Our Ref: FP/220/19/HH

**Town & Country Planning Act 1990 (as amended)
Town & Country Planning (Development Management Procedure) (England) Order 2015
Application for Planning Permission for Works or Extension to a Dwelling**

Development Single storey extensions to front and rear elevations, all existing windows/doors/balcony to be replaced and new slate roof

Location 14 Sea Drive Felpham

PROJECT NO.
PA-319-05
DRAWING TITLE
Proposed Site &
Location Plan

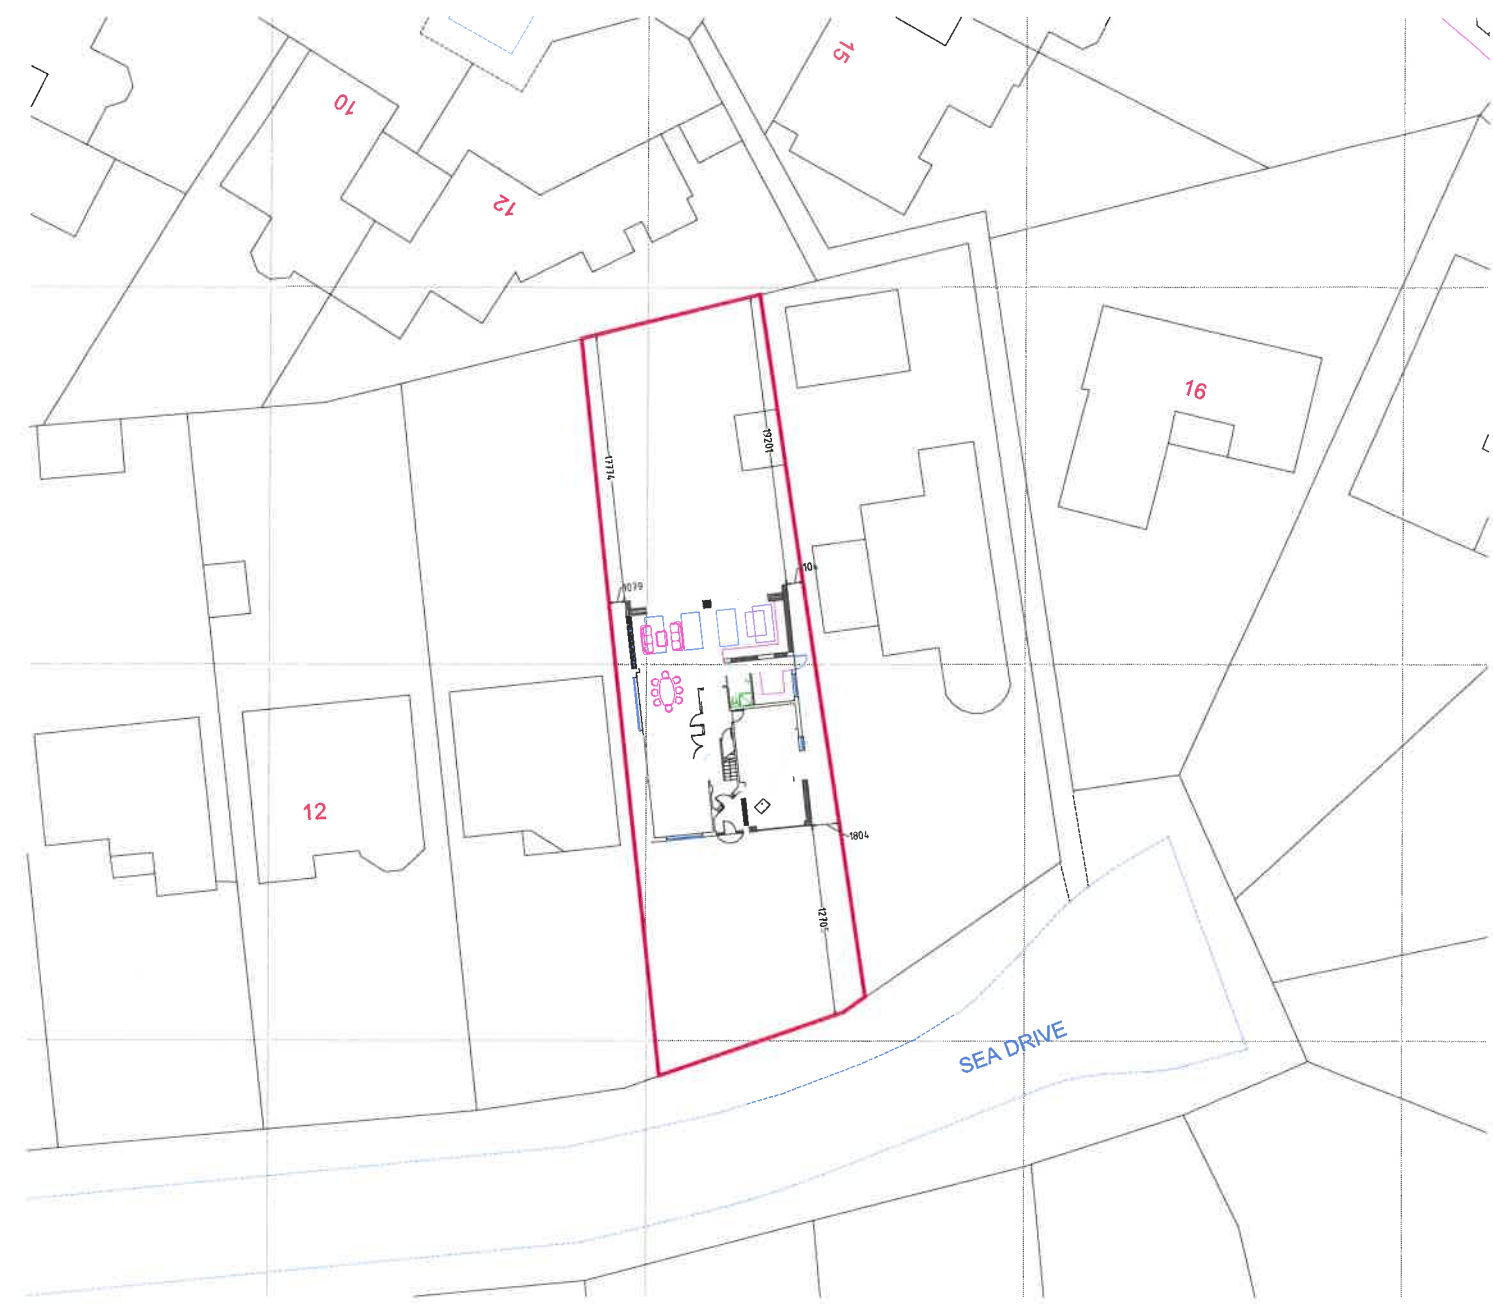
You are required to show the dimensions from the proposed extensions to the site boundaries on the block plan. These are also unreadable.

Front Elevation - Facing South

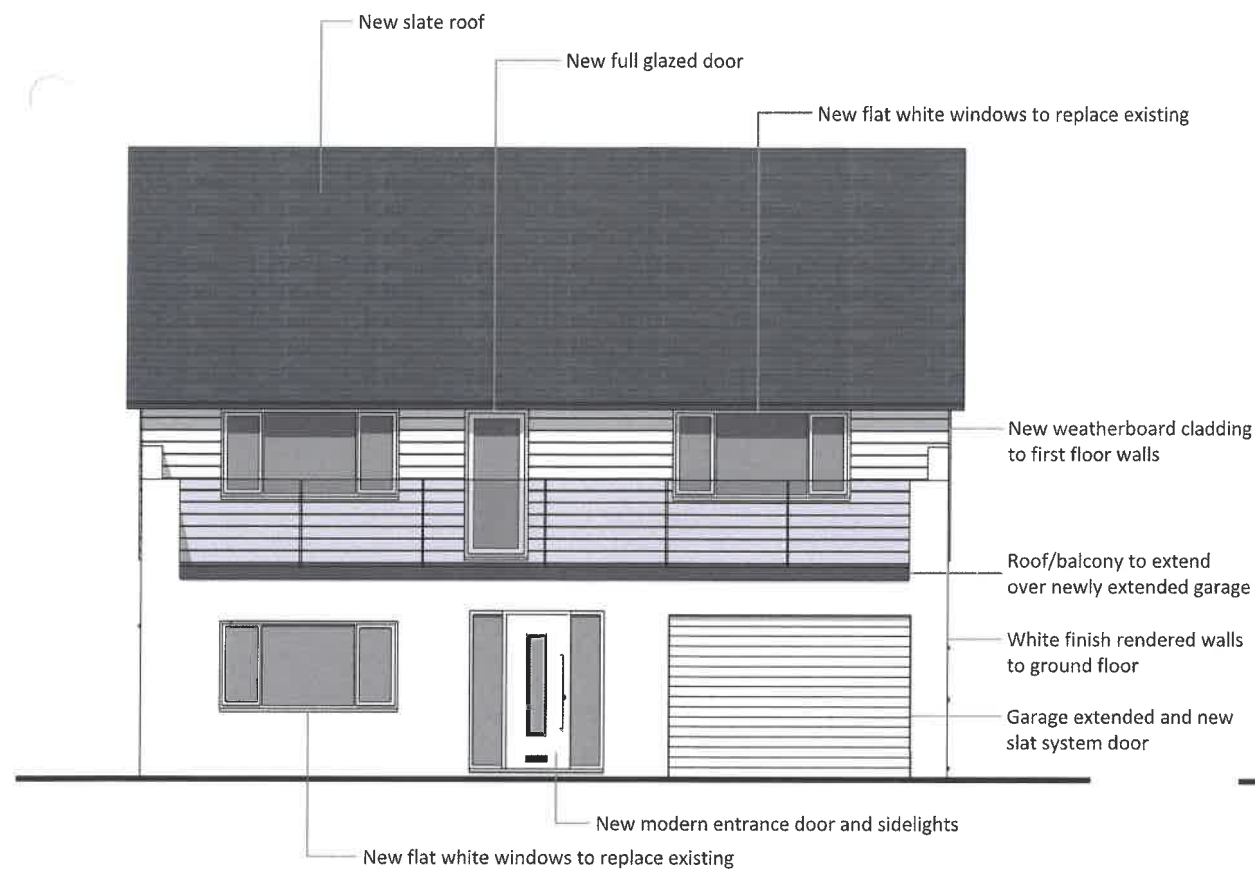
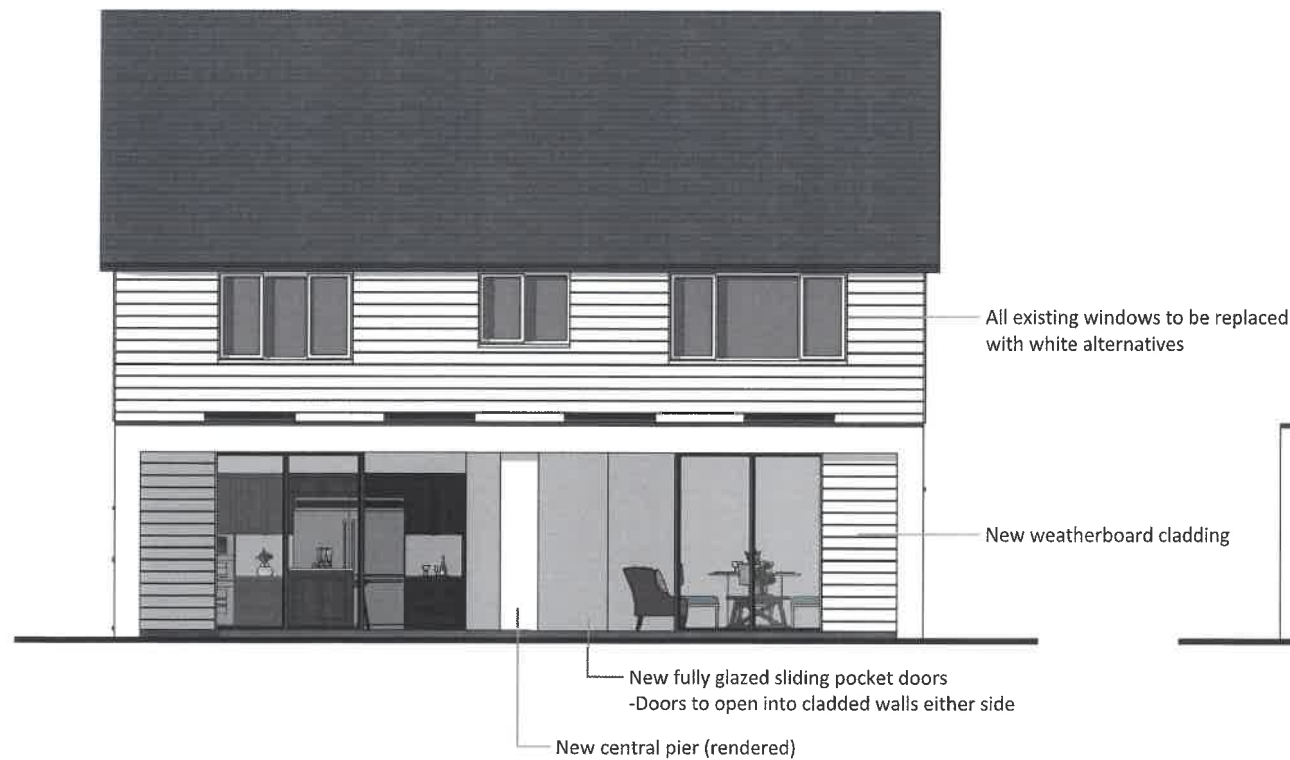
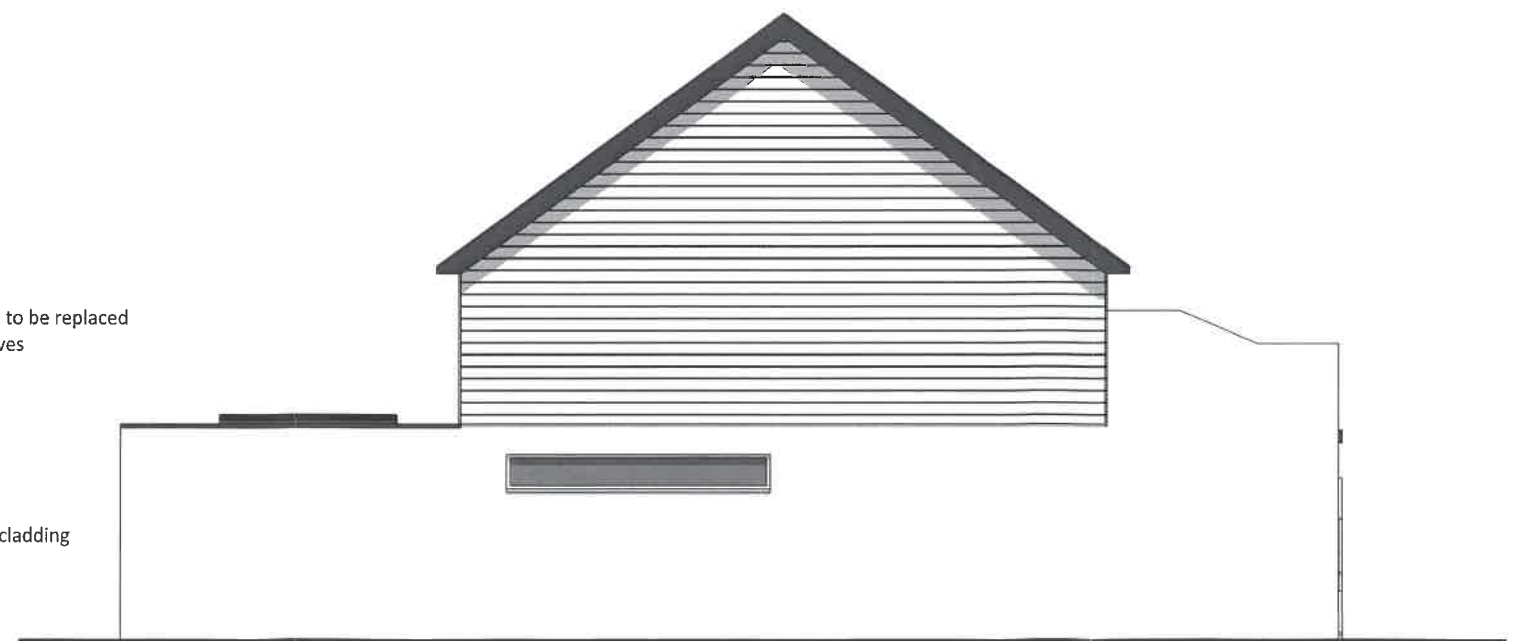
The overall quality of the the proposed plans and elevations are poor.

The dimensions and annotations are unreadable.

The building lines are unclear on the proposed elevations.

Please submit clearer versions of the proposed plans.
